CITY OF ALBUQUERQUE

December 13, 2013

Re: Guardian Storage, Holly Ave NE
180 Day Temporary C.O. - Accepted
Engineer's Stamp dated: 1-29-13 (C-19/D056)
Certification dated: 12-12-13

GRADING & DRAINAGE PLAN

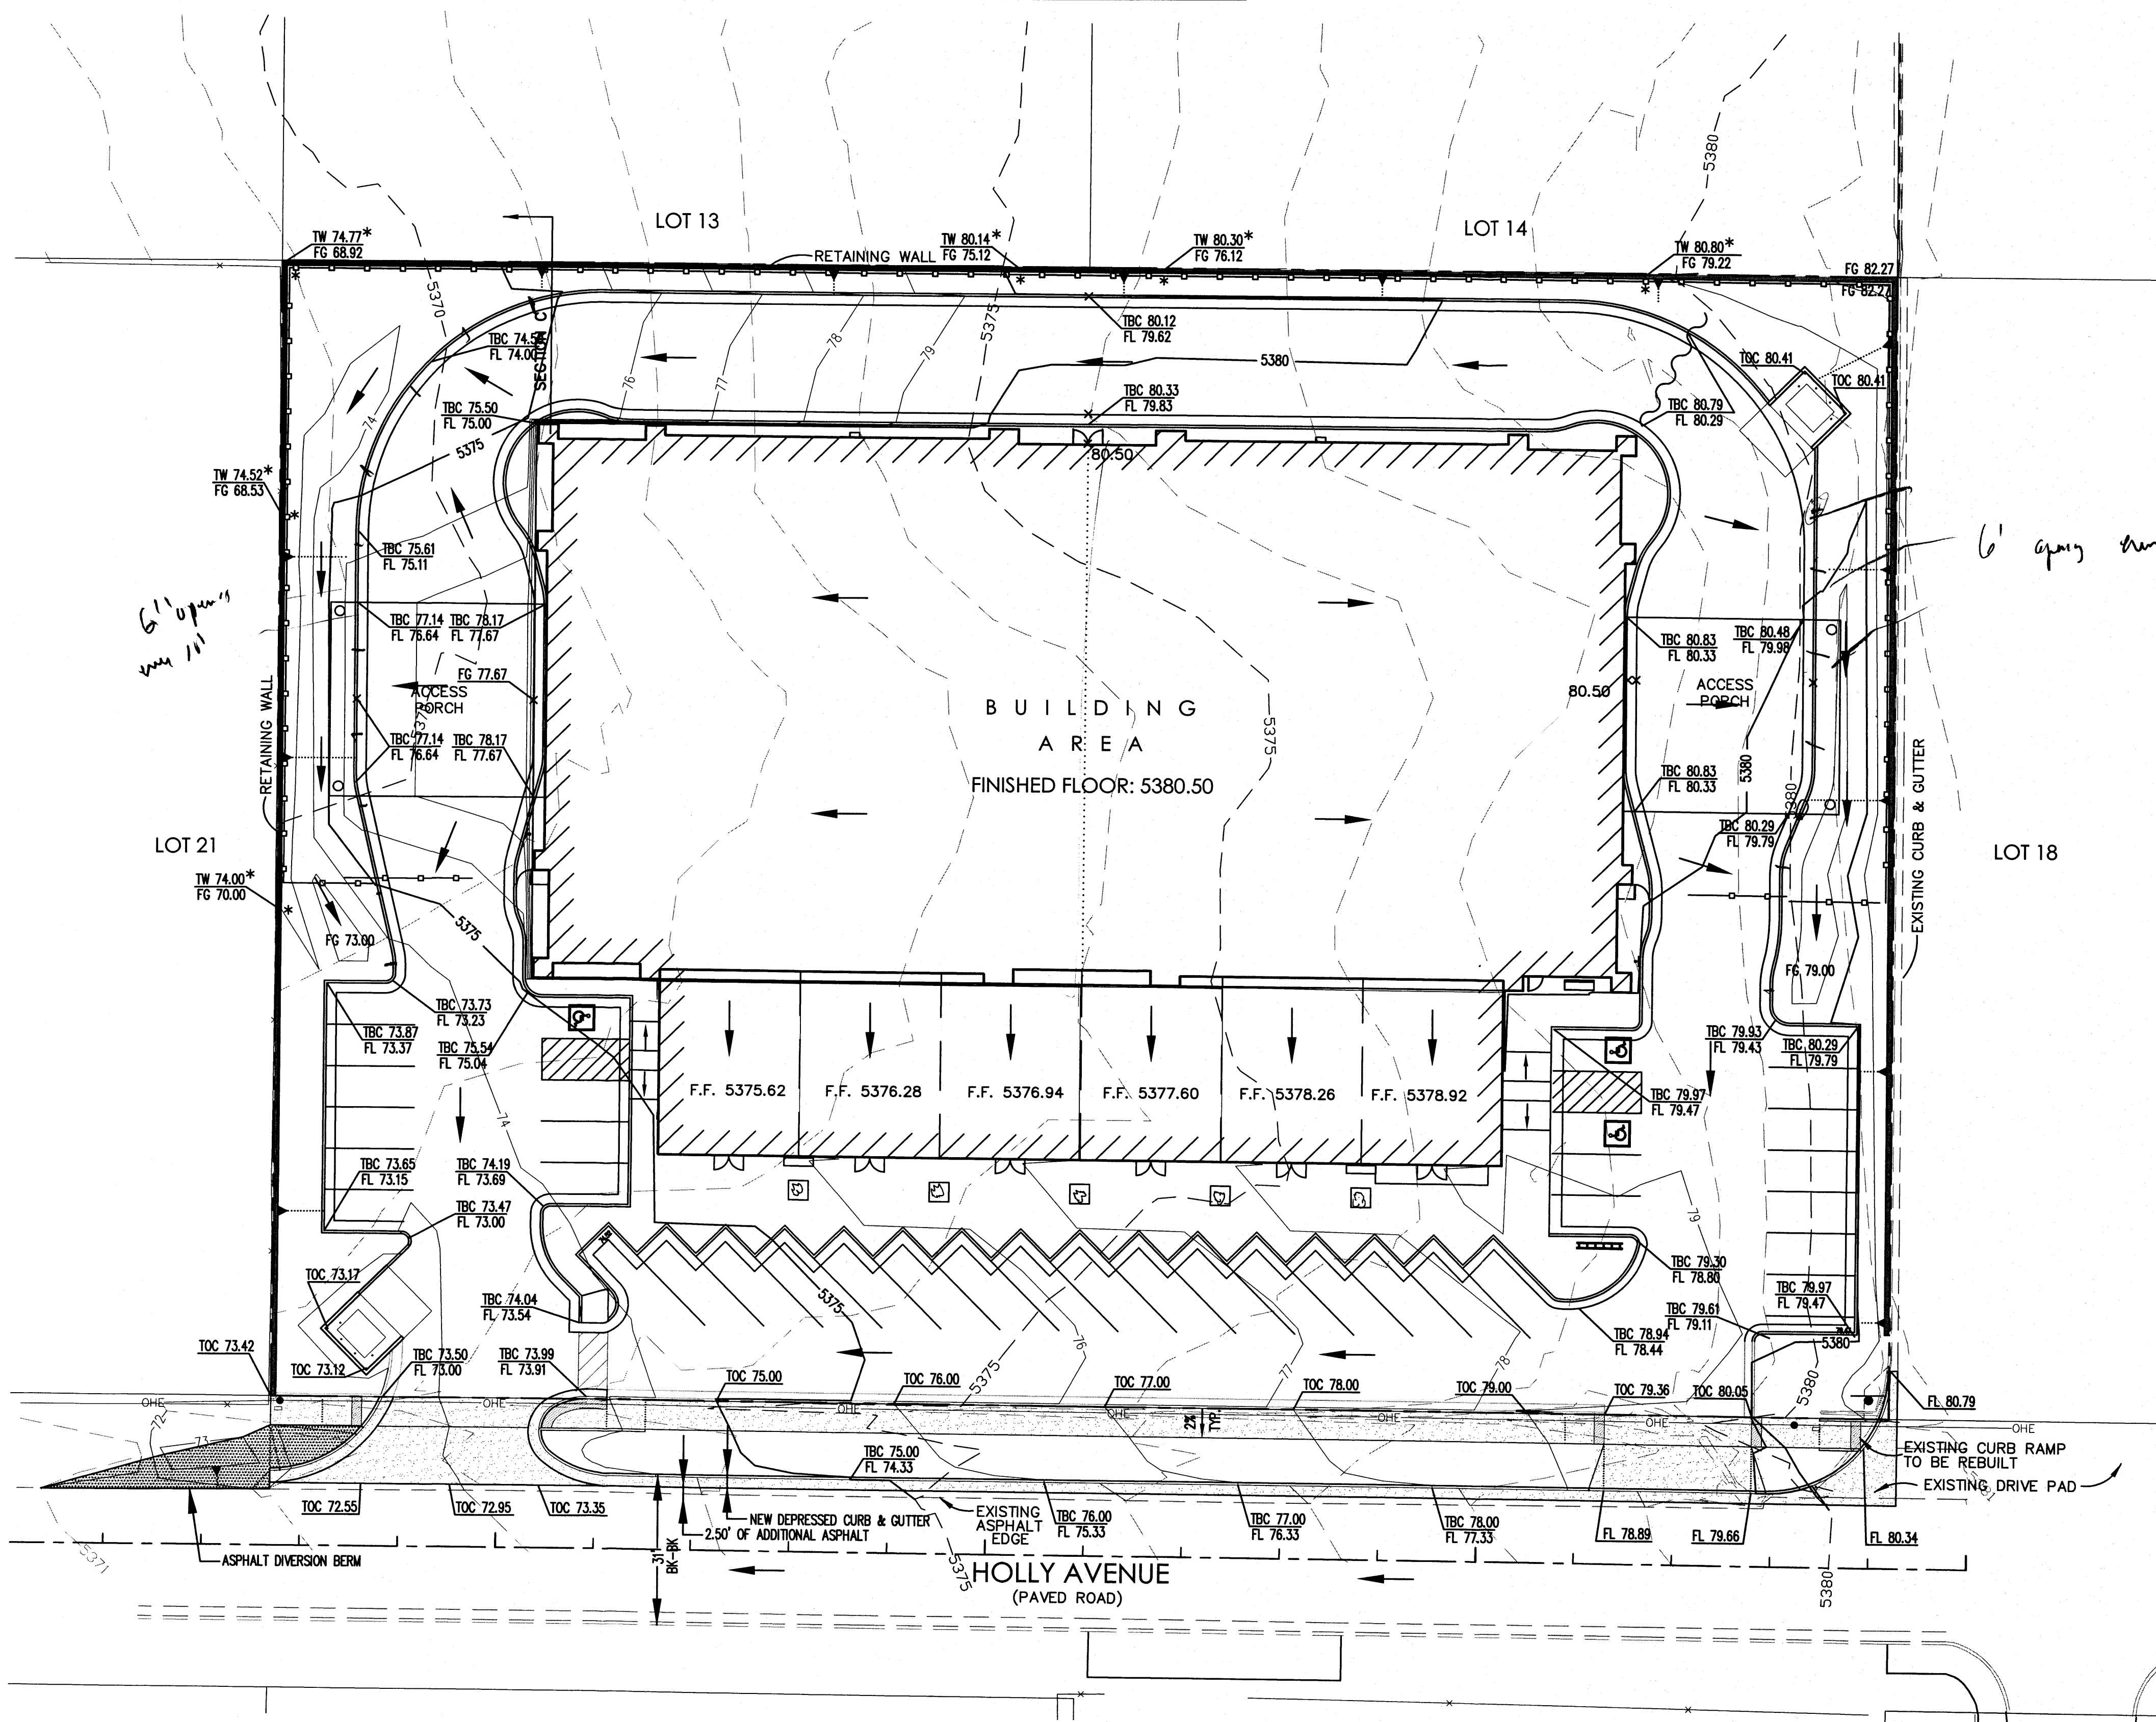
- The asphalt Diversion Berm on Holly Ave. is not functioning as required. The asphalt berm should be directing flows across Holly Ave and not allowing erosion on the edge of Holly Ave and entering the property to the west of Guarding Storage.
